Tree Conservation Report Addendum submitted as
Partial Requirements for a Site Plan Control Application,
August 25, 2026

Application: D02-02-26-0012 (Minor ZBLA) and D07-
12-26-0014 (SPC)

TREE CONSERVATION REPORT ADDENDUM 4.0

71 Russell Ave

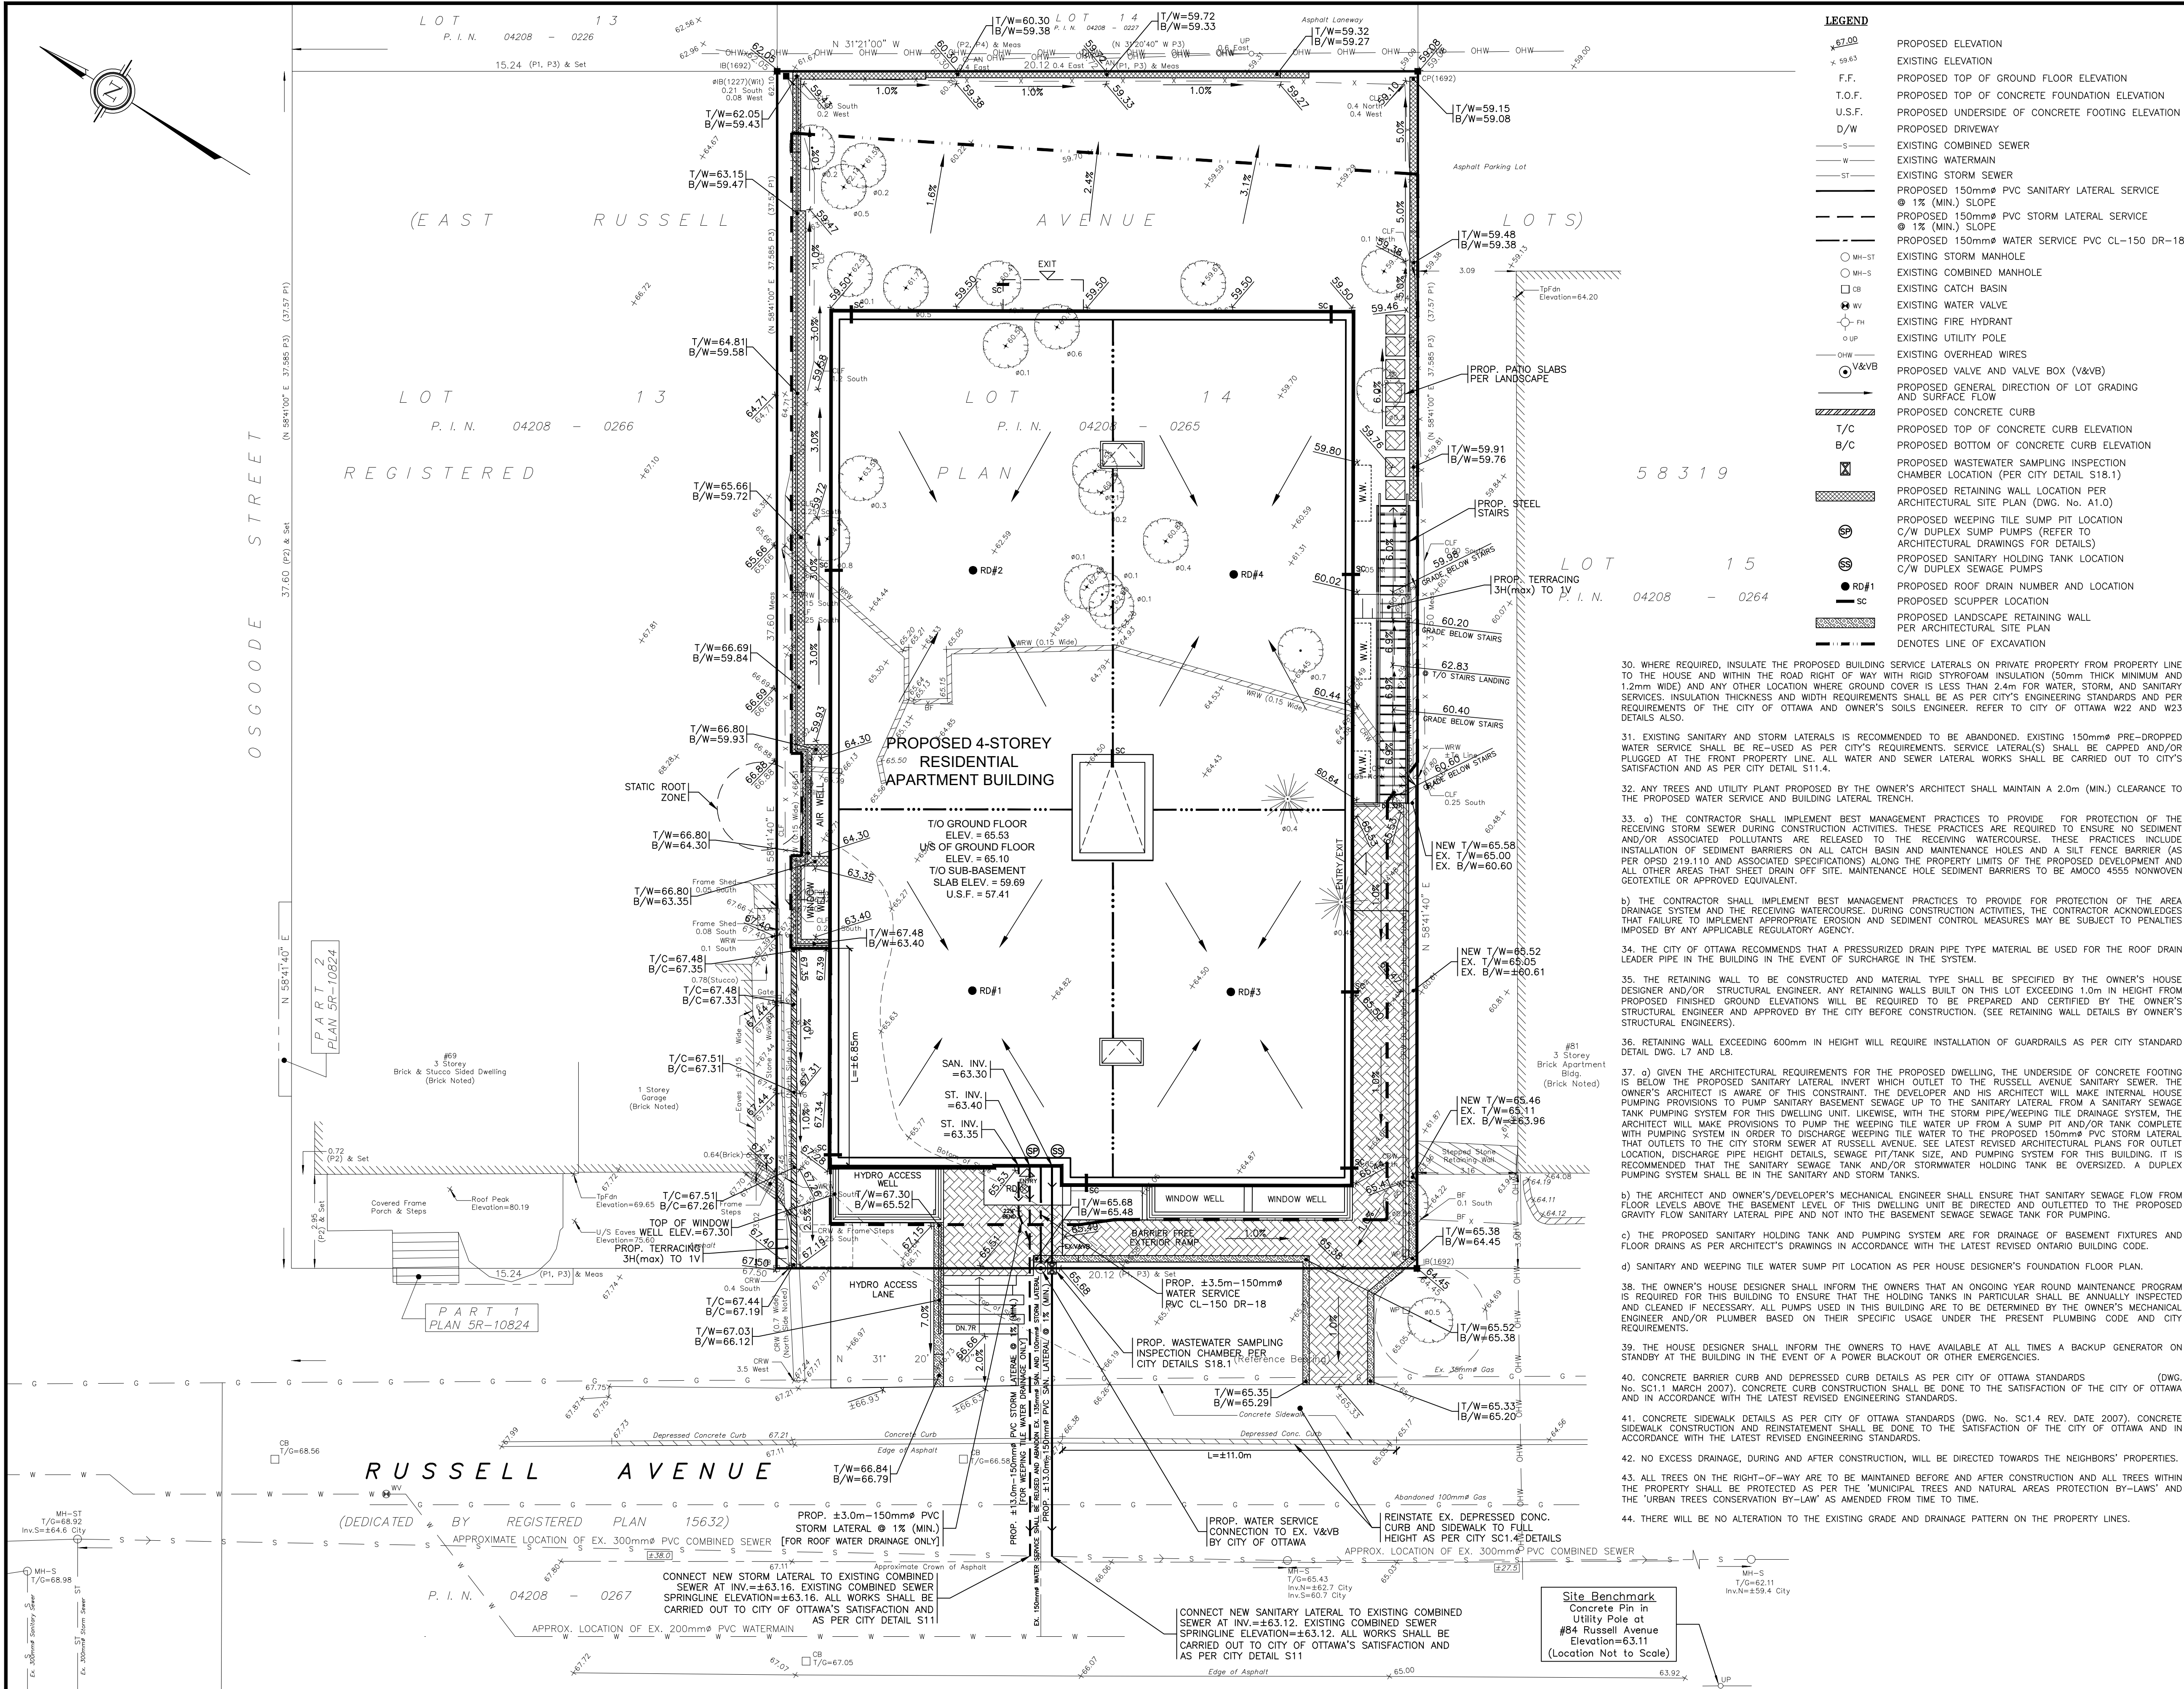
o The static root zone of a tree is defined by the International Society of Arboriculture Best Management Practices as the tree's diameter times three. For a 45cm diameter tree, the static root zone would be 1.35m. No lateral cut to a root shall be made in this area without risking instability. The TCR states the wooden structure on site was 40cm from the L bend and 90 cm to centre of the tree. The excavation to install the shoring is stated as being 20 cm closer to the tree than the wooden wall. This does not align with the ISA BMPs that suggest no roots should be cut in a tree's static root zone. The TCR needs to outline what the static root zone for this tree is and how far excavation/root pruning would need to be from the tree to avoid compromising this trees health and stability. This must align with the civil plans.

o The extent of excavation must be clearly shown on the TCR. The location of the tree protection fencing for tree #10 must be shown on the civil plans. This is to ensure the plans align with one another.

The project team has redesigned the wall to include a notch around the tree that relocated the shoring and proposed retaining wall to follow the path of the previous wooden wall, which followed the extent of the roots on the subject property immediately adjacent to the tree. The image below shows the updated site plan that includes the surveyed location of the tree and the location of the old wooden wall (extent of roots) as the dashed blue line. The green line represents the extent of excavation via shoring. This notching also demonstrates how the roots beyond the elbow of the old wall that will be severed as part of the shoring installation are outside of the static root zone, which is defined as three times the diameter of the tree. Although the diagram shows the measurement of the static root zone from the centre of the tree, the excavation is still outside of the static root zone if measured from the edge of the tree (an additional 23 cm).

The grading plan prepared by TL Mak was also updated on August 24, 2026, to reflect the addition of this notch. Below is a snapshot of this plan that includes the static root zone of the tree:

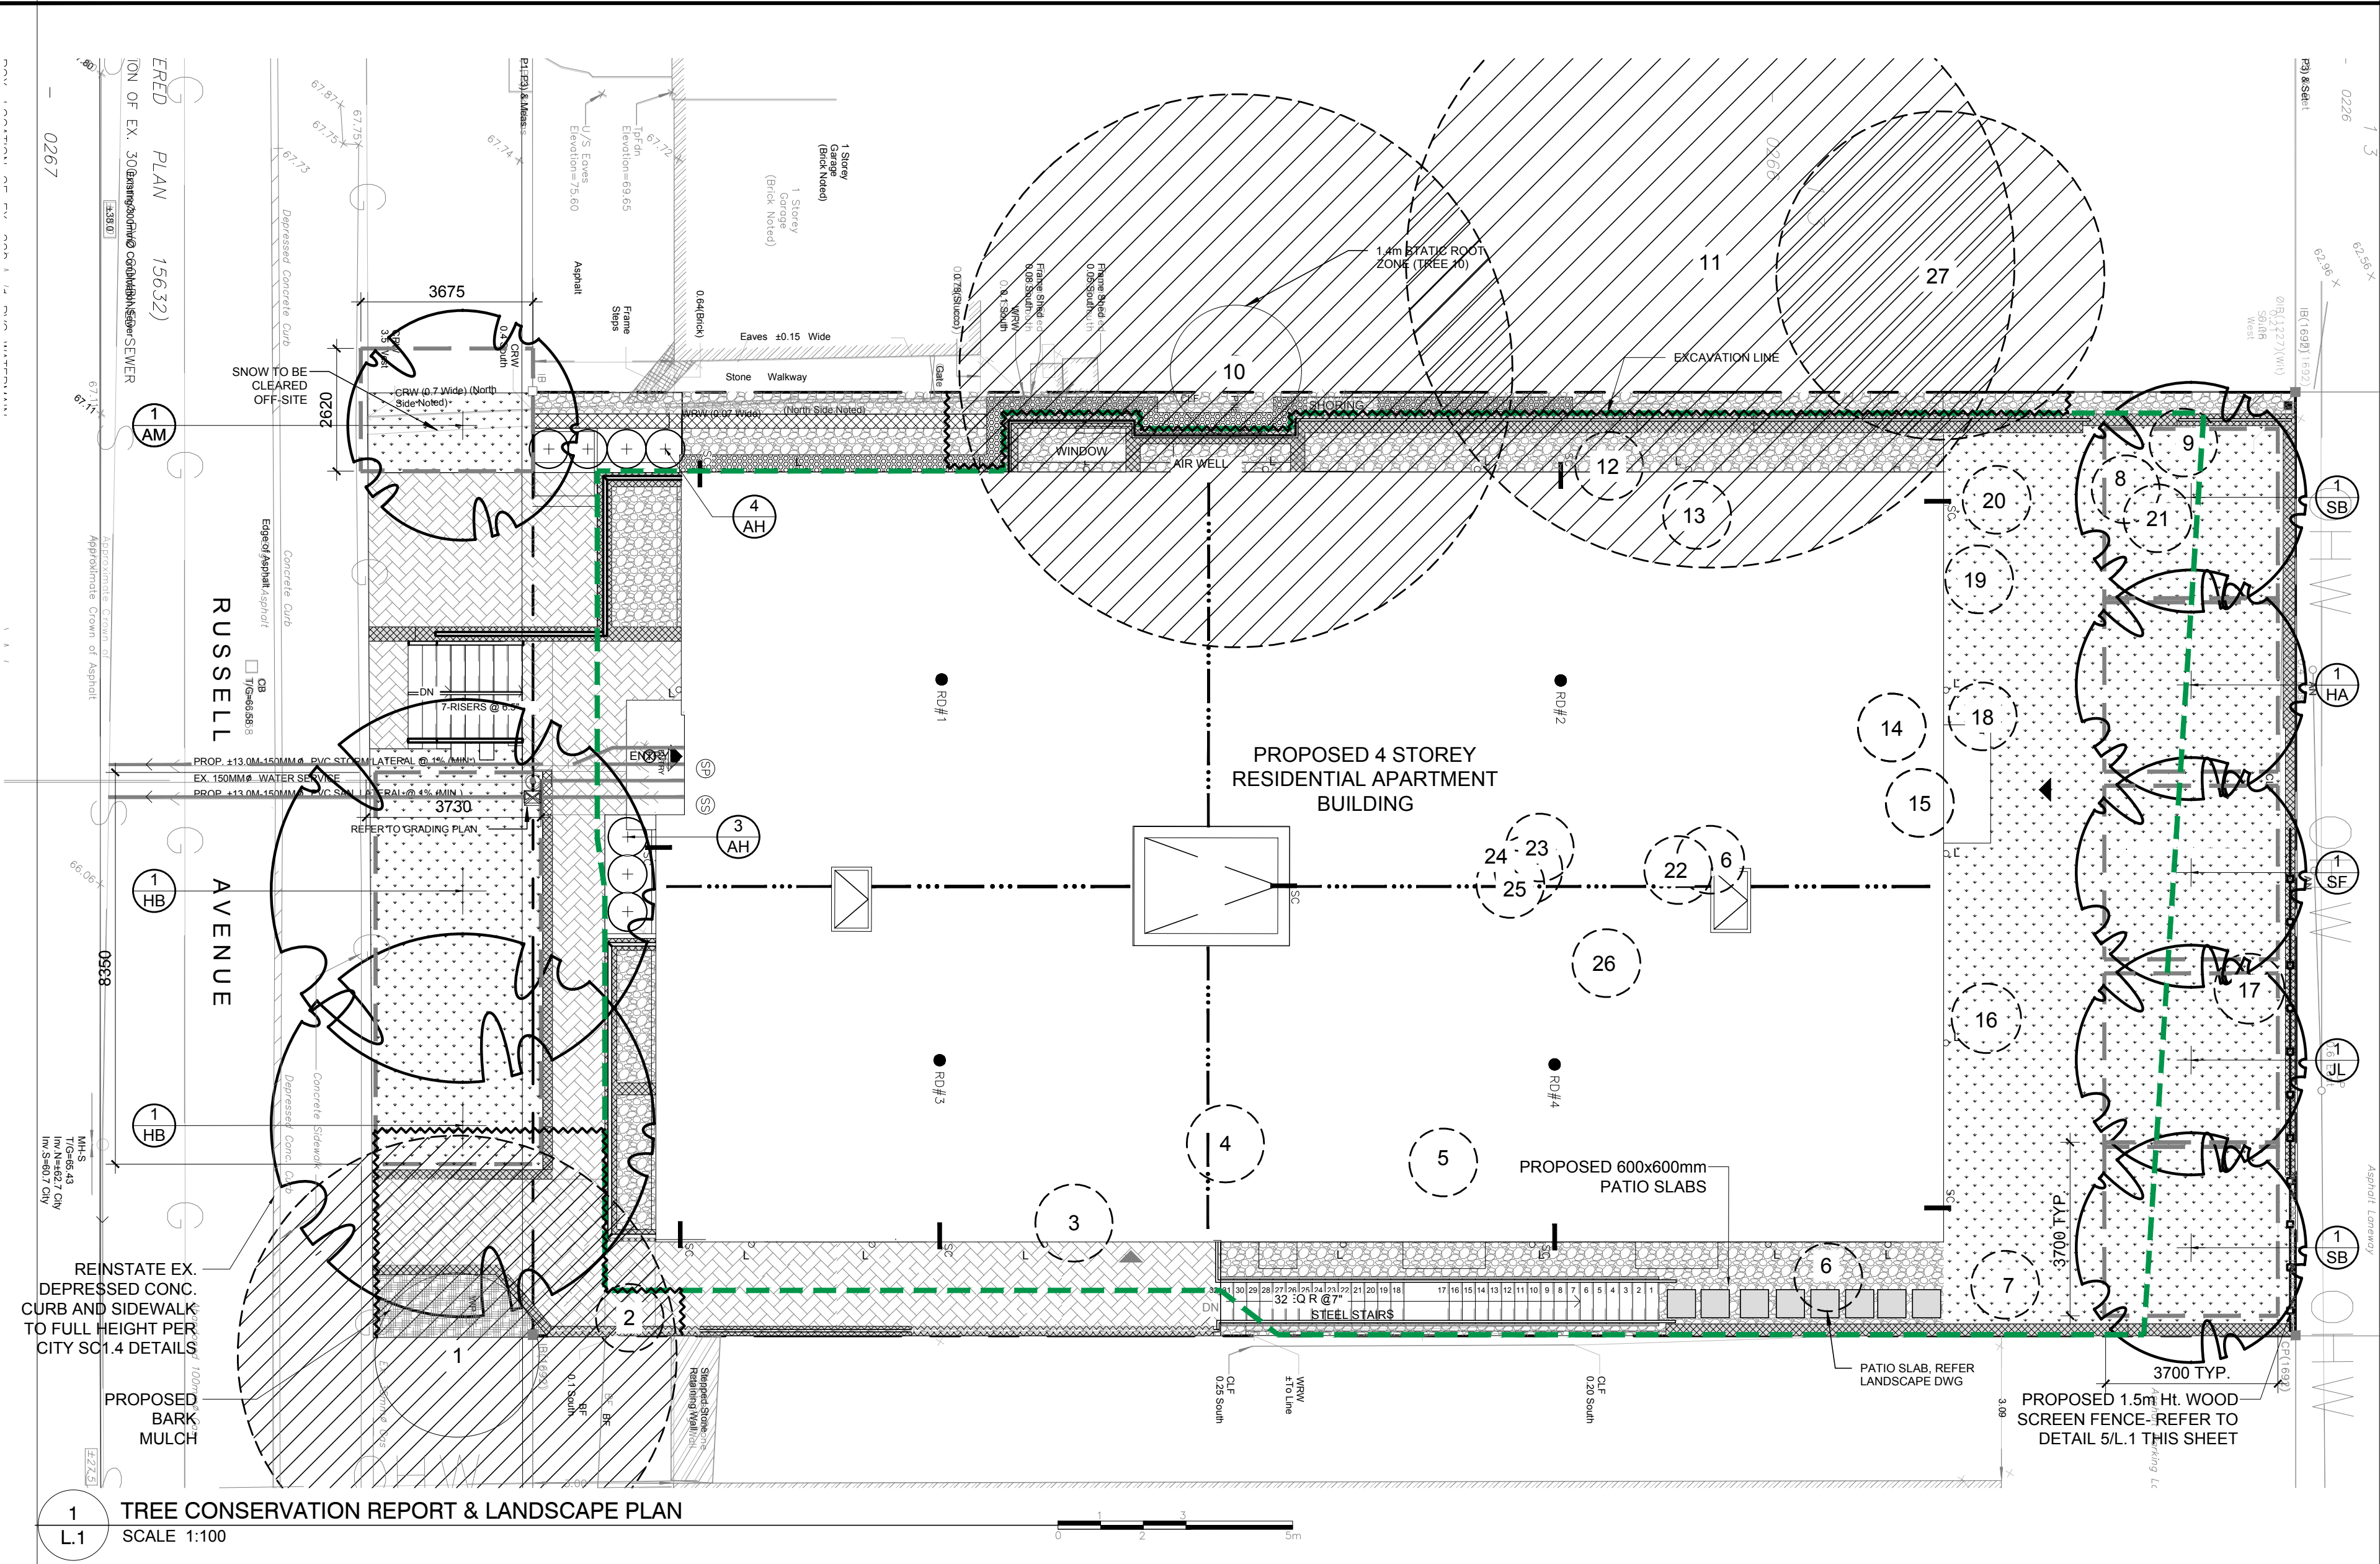
o The diameter of tree #10 must be confirmed as prior versions of the TCR, provided by Lennox and Associates, identified the tree as being 60cm in diameter. Please provide written confirmation (by email) of the tree's current diameter. It must be updated in the TCR addendum if it is not 45cm in diameter.

The diameter measured at the base was 49 cm, and it is estimated to be 47 at breast height (1.3 m above grade). Based on this diameter, the static root zone would be approximately 1.4 m from the tree.

Please see the updated TCR prepared by James B Lennox & Associates Inc.
